## Network Rail Consultation Response

<b>FAO:</b>	William Simcock
<b>Date:</b>	20 May 2021
<b>Application reference:</b>	2021/91795
<b>Proposal:</b>	Erection of 7 dwellings
<b>Location:</b>	Manashay Cottage, Upper Brow Road, Paddock, Huddersfield

CLIENT			
CREATIVE DEVELOPMENTS			
PROJECT			
RESIDENTIAL DEVELOPMENT UPPER BROW ROAD PADDOCK HUDDERSFIELD HD1 4UP			
DRAWING TITLE			
PLOTS 7 PROPOSED PLANS AND ELEVATIONS			
Rev.	Notes	Date	Drawn
SCALE	1:100 @ A1	10.20	PB
PROJECT No.	DRAWING No.	Rev.	
1976	06	-

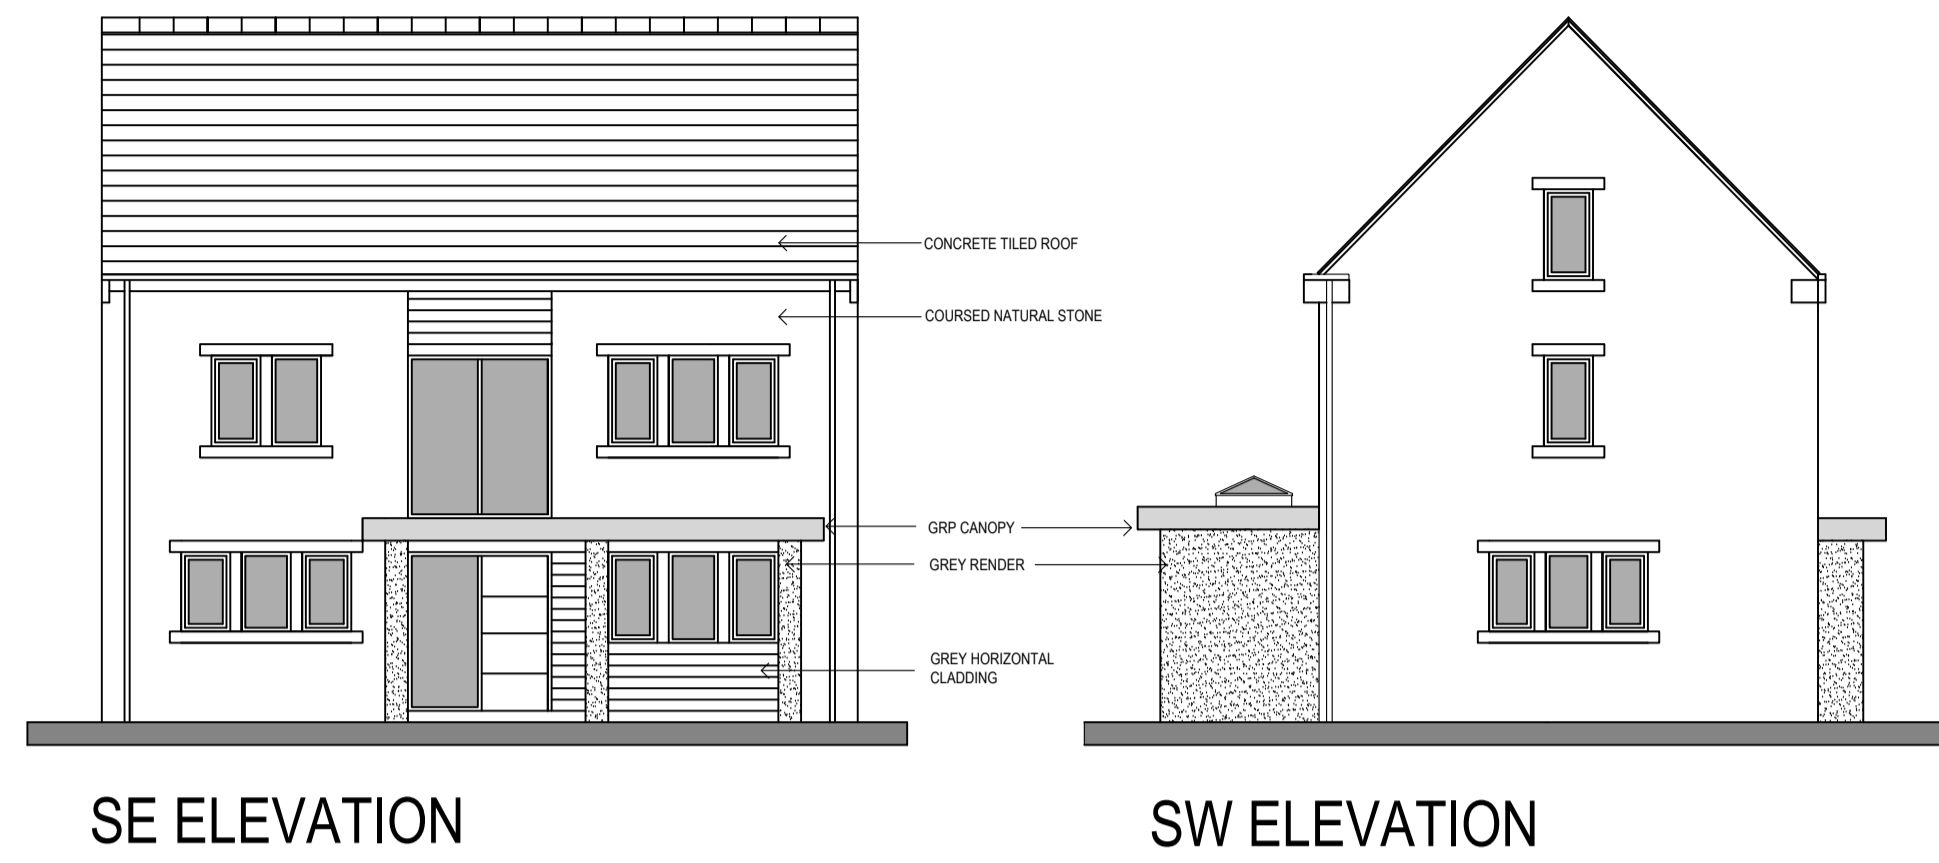
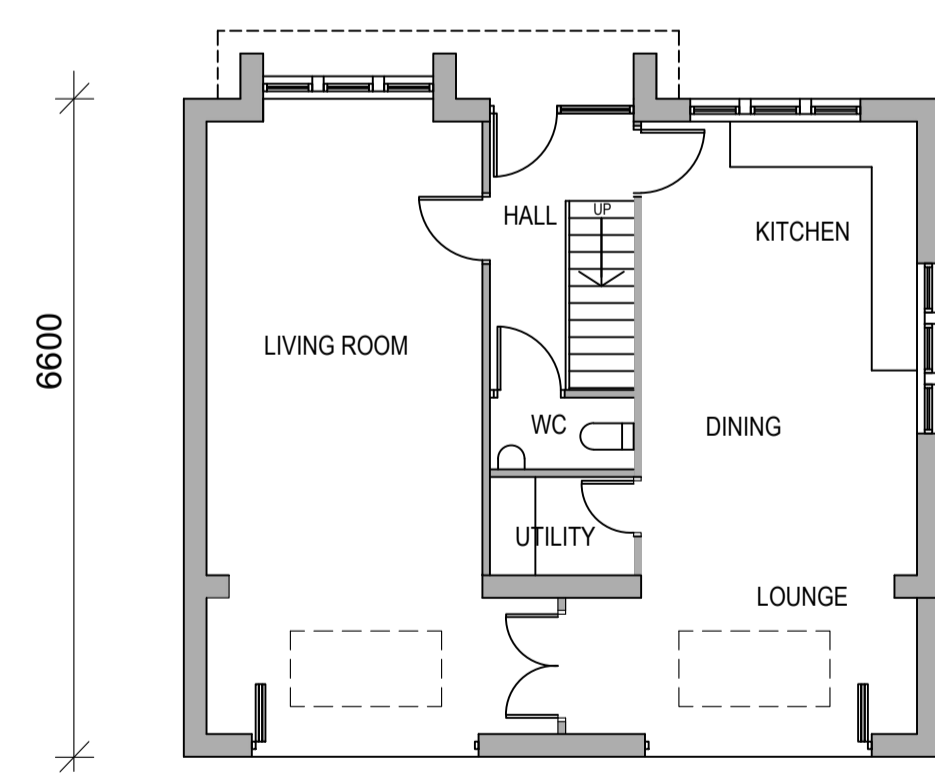
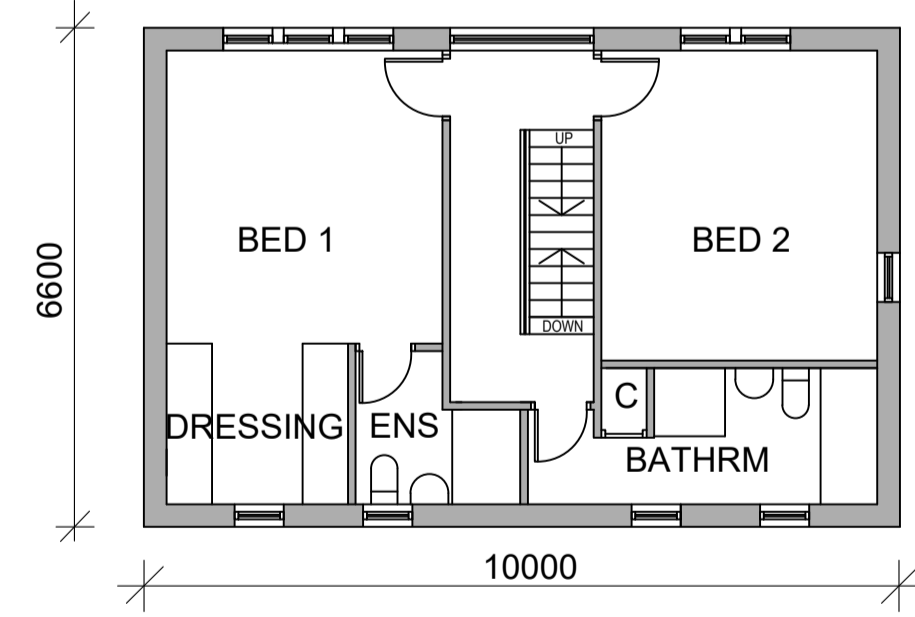
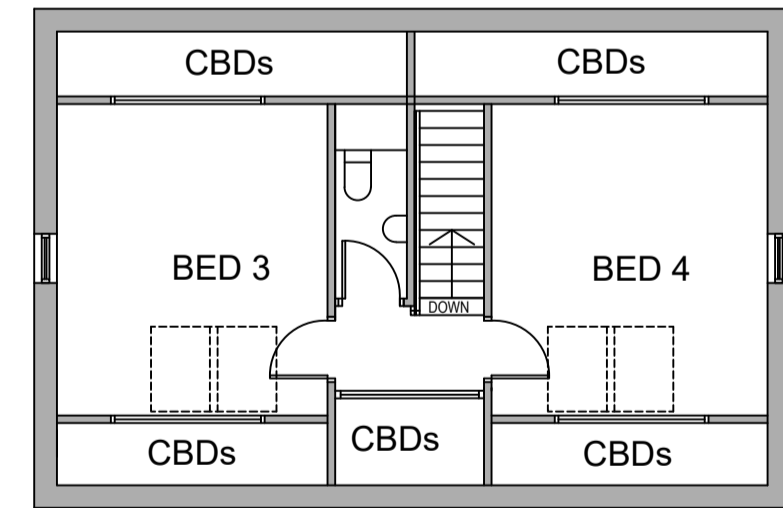
Trespass onto the railway is a criminal offence. It can result in costly delays to rail traffic, damage to the railway infrastructure and in the worst instances, injury and loss of life. Due to the nature of the proposed development we consider that there will be an increased risk of trespass onto the railway. In this instance, this will have particular relevance to Plot 7.

The developer must provide a suitable trespass proof fence adjacent to Network Rail's boundary (approx. 1.8m high) and make provision for its future renewal and maintenance. Network Rail's existing fencing/wall must not be removed or damaged.
